About the application

Application number: 2024/90678	
What is the application for?:	Erection of detached dwelling (within a Conservation Area)
Address of the site or building:	adj, Carr Mount, Cooper Lane, Holmfirth, HD9 3HU
Postcode:	HD9 3HU

south east elevation (front)
1 : 50

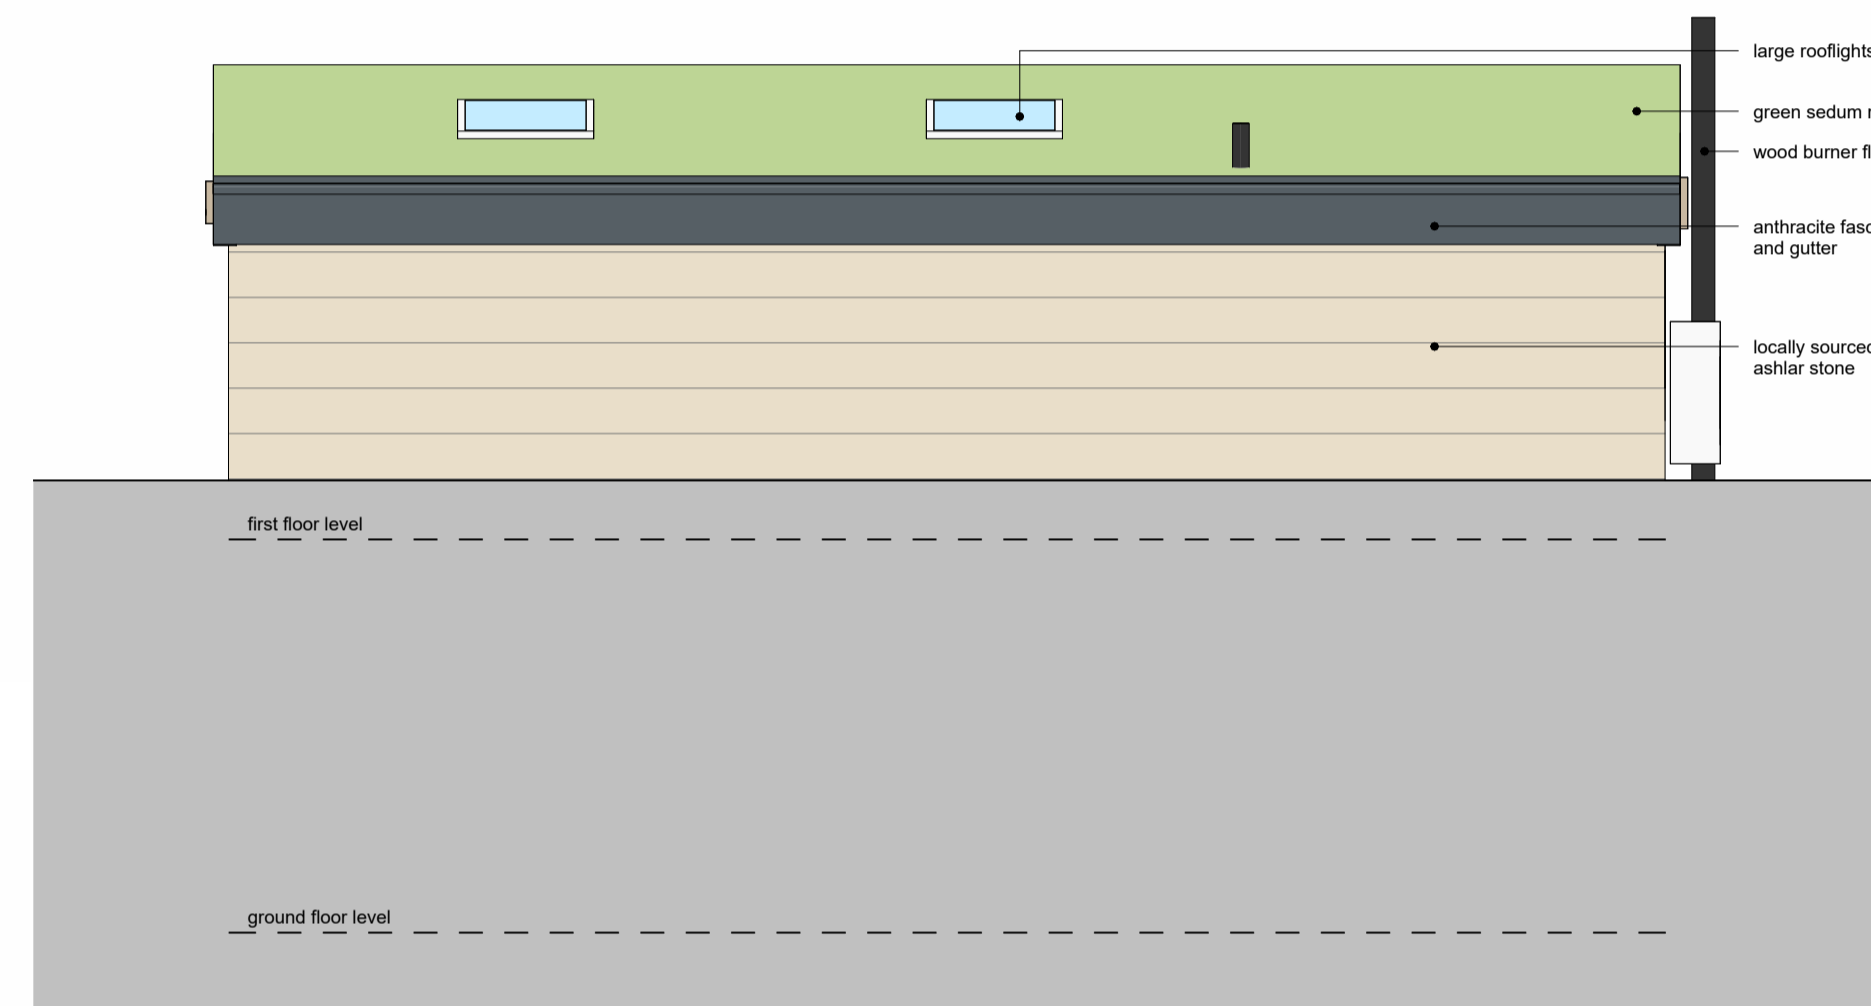
Type of comment: An objection	
Do you wish your comments to be published on the website anonymously?	Yes
I have no objection to the principal of a house of this size on this site, but I feel strongly that the fully glazed frontage is very much out of place in our conservation area. As the application says, the buildings on Hightown Lane were built in mid 1800s to early 1900s and feature stone walls with sash windows. The front of this building will be incongruous.
